The Drovers Solar Farm

Appendix 12.1: Consultation and Legislation, Planning Policy and Guidance (Tracked)

Document reference: APP/6.4.1 (Revision 1)

DRAWING TITLE:
ES Figure 12.2 Indicative Watercourse Crossing

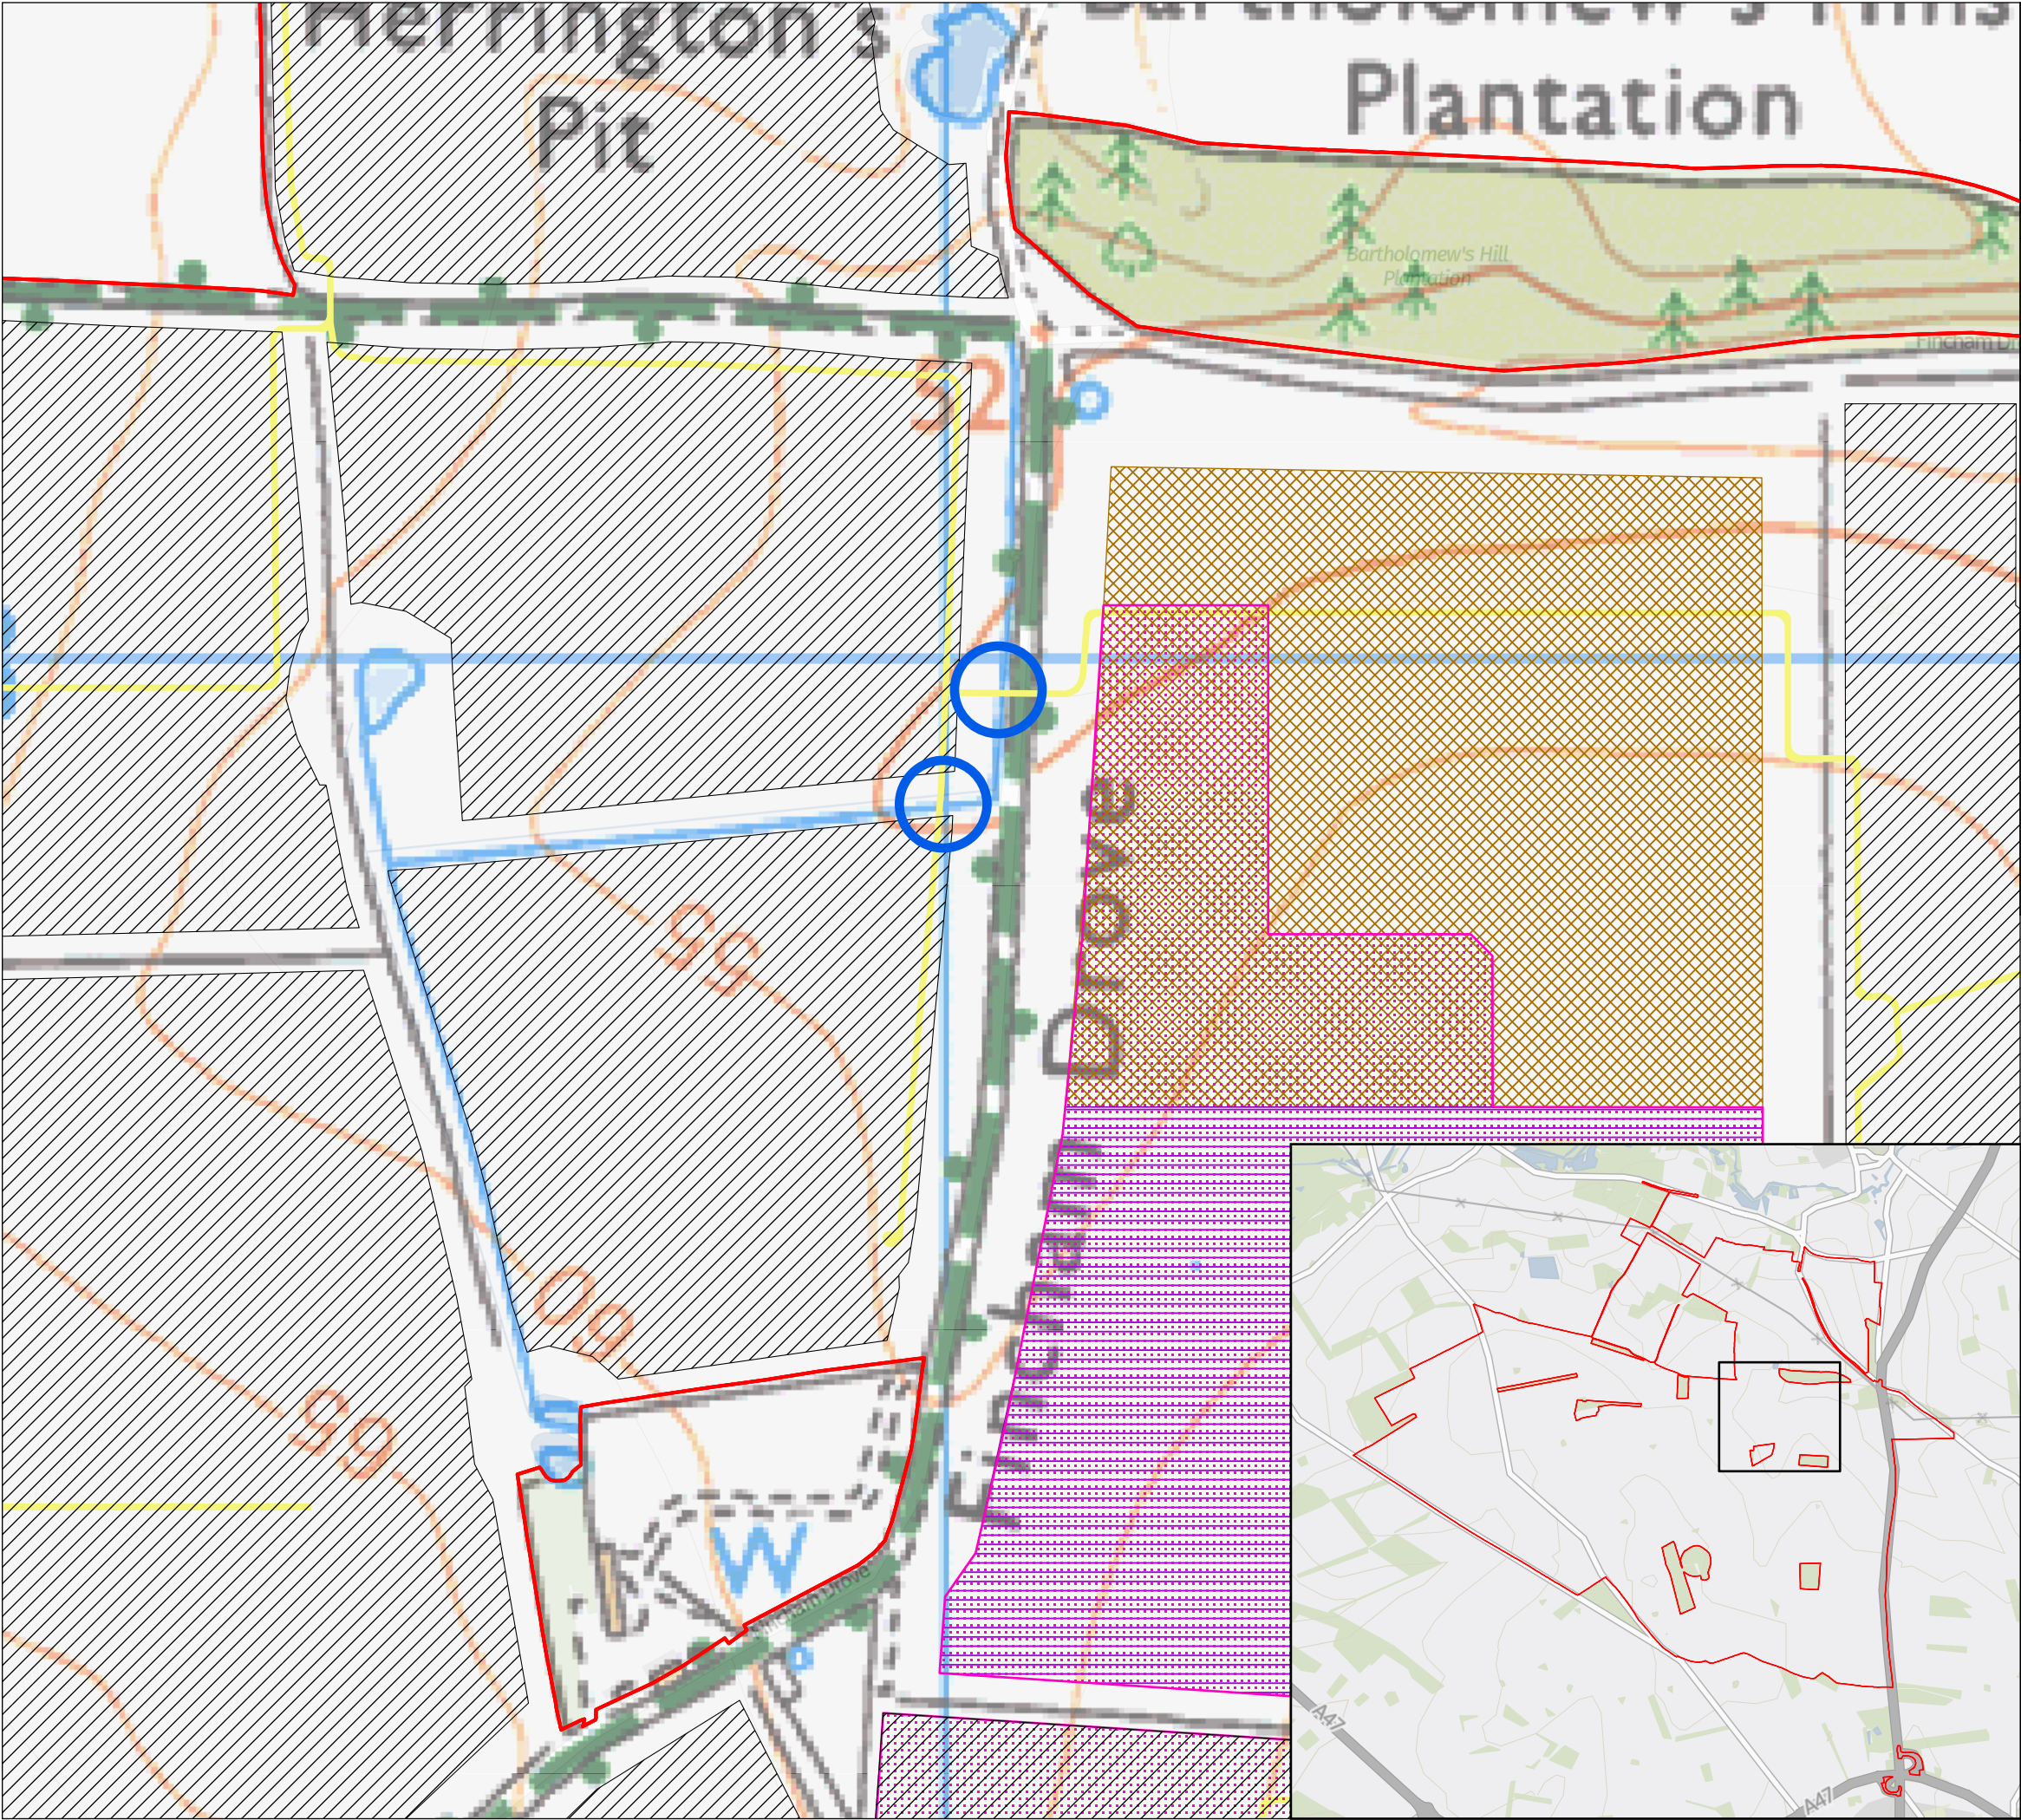
reminds the applicant that compacted material is considered impermeable and sustainable surface water management will be required for these temporary compound areas and new or improved temporary and permanent access track.		
	As this development covers a large area, a phasing plan supported by a construction phase surface water drainage plan will also be required to demonstrate there is no increase in flood risk in the construction phase (further information is provided in the LLFA's Developer Guidance). Otherwise, the proposed development could be considered not in accordance with the principles of NPPF and sustainable drainage.	A phasing plan will be provided as part of the detailed design of the Scheme following granting of the DCO, once a construction contractor has been appointed.	N/A
	Please note, if there are any works proposed as part of this application that are likely to affect flows in a river or watercourse, then the applicant is likely to need the approval of either Norfolk County Council, the Environment Agency or the local Internal Drainage Board. In line with good practice, these organisations seek to avoid culverting where possible. For Norfolk County Council, the consent for such works will not normally be granted except	Regarding watercourse crossings, the design of the Scheme does not have sufficient detail to confirm the exact locations of crossings at this stage. However, it is anticipated that the Scheme will require two crossings of a 'blind' / dead end ditch, which is not classed as an Ordinary Watercourse or Main River and which falls outside of the EA or LLFA remit for approval or issuing of consent. In any event, the draft DCO [APP/3.1] contains protective provisions for the benefit of the EA and drainage authorities.	Figure 12-2 of ES Chapter 12: Water Resources [APP/6.2] .

as a means of access. It should be noted that this approval is separate from planning.	The crossing locations are shown on Figure 12-2.	
	The LLFA notes the requirement for construction compounds however, there is no indication of the approximate location and number of them to support the development of the proposed site. Furthermore, the LLFA notes that as the site is to have a lifespan of 60 years, yet the design life of the PV panels is approximately 25-40 years and the batteries are 15 to 20 years, these structures are likely to be replaced at least once but more likely twice during the scheme's lifetime. The LLFA queries whether the permanent maintenance compounds to facilitate these maintenance activities will be provided with an associated impermeable area. The LLFA will require clarification on the location, duration and the surface water drainage arrangements for each of these construction compounds is requested to be included in the submission.	Maintenance compounds are not required for the operational phase of the Scheme. The oCEMP [APP/7.6] outlines how SuDS will serve Temporary Construction Compounds.	See section 3.8 of the oCEMP [APP/7.6] , which is secured via requirement of the Development Consent Order (DCO) Application.
